DRB Application No.: 06DRB-00220 (P&F)
Project Name: JOHN M MOORE REALTY CO.
ADDITION #3
Agent: Justin Simmons

Project # 1004458
Phone No.: 710-7878

ITEM # 13

RE: John Moore Realty Company's Addition No. 3/p&f

**PLAT**  
 OF  
**LOT 4-A and 4-B**  
**BLOCK "C"**  
**JOHN M. MOORE REALTY COMPANY'S ADDITION NO. 3**  
 TOGETHER WITH EASTERLY 10' VACATED ALLEY  
 TOWN OF ALBUQUERQUE GRANT  
 PROJECTED SECTION 18, T.10N. R.3E., N.M.P.M.  
 ALBUQUERQUE, BERNALILLO COUNTY, NEW MEXICO  
 DECEMBER 2005

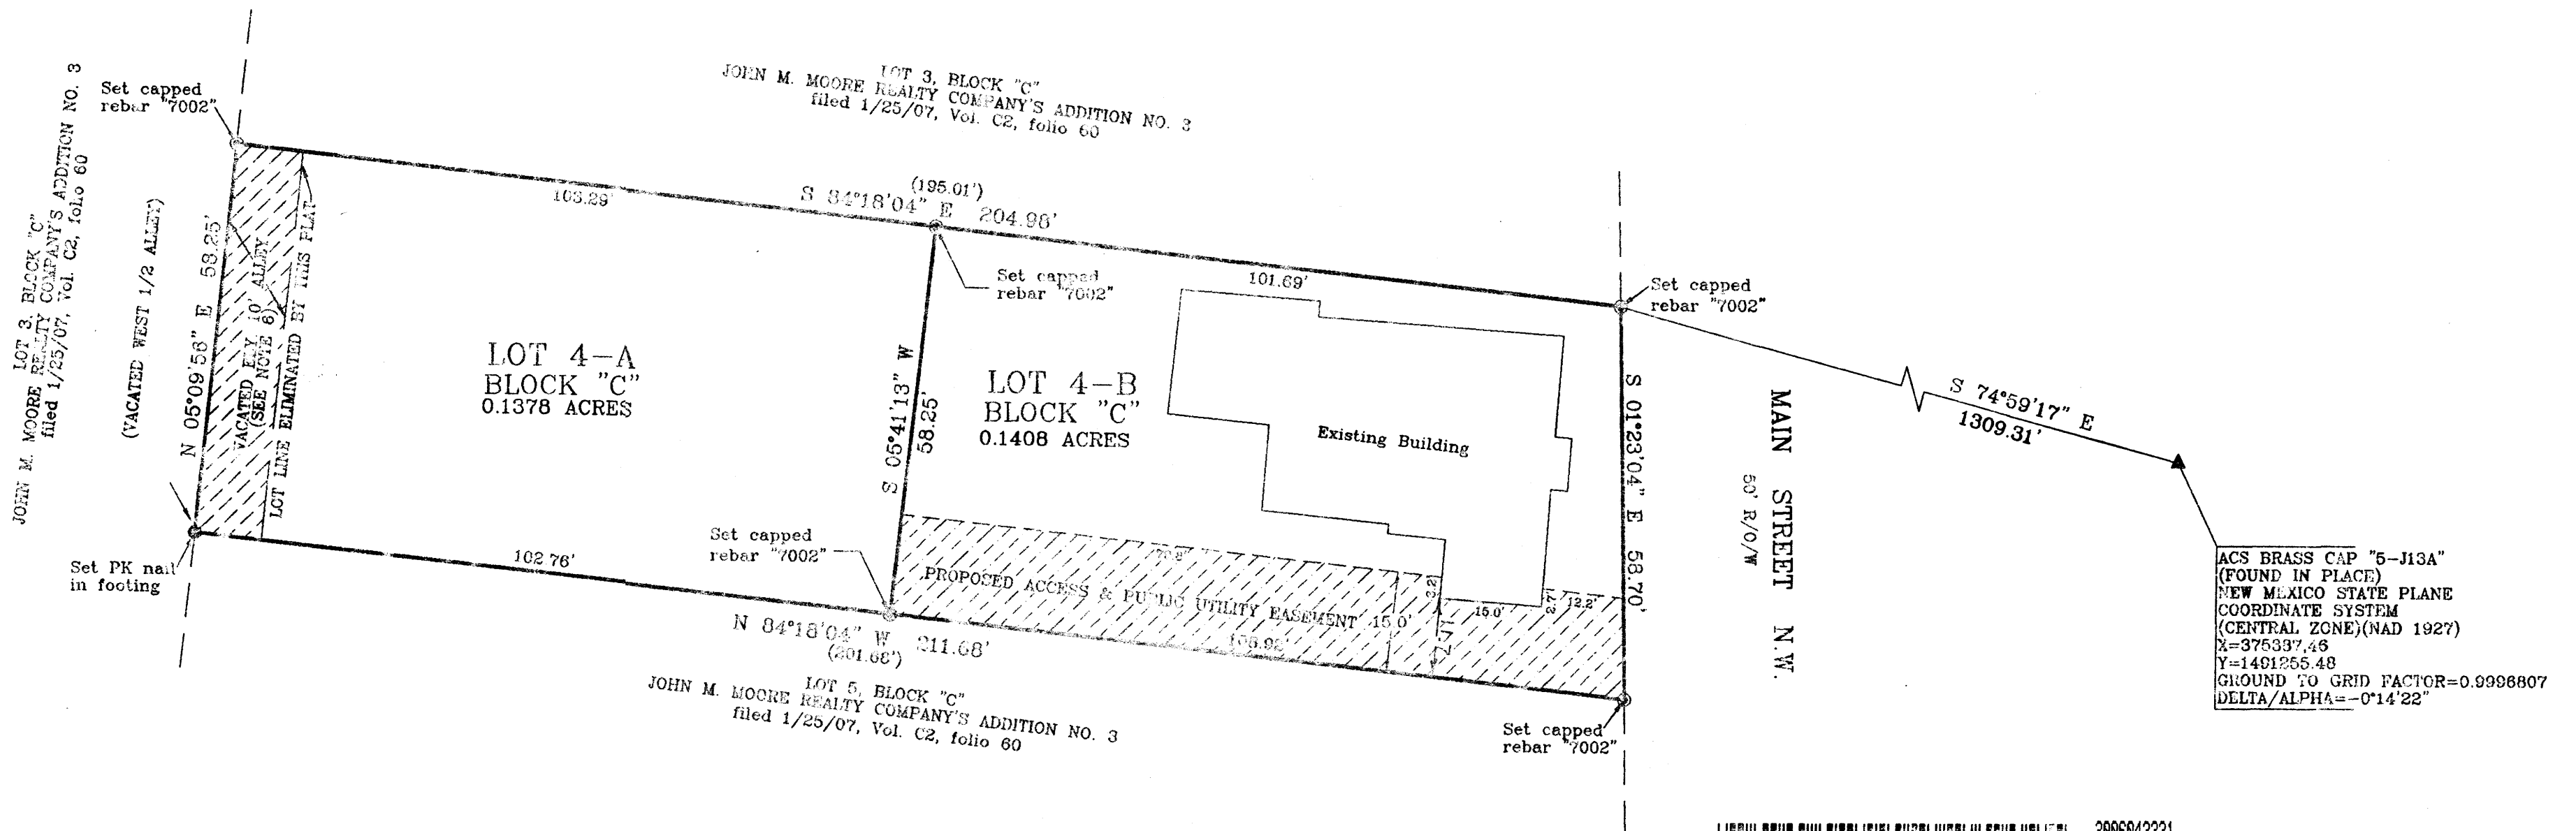
TRANSPORTATION: ACCESS EASEMENT NEEDS TO BE 15' WIDE
LAST MAINTENANCE & REPAIRS
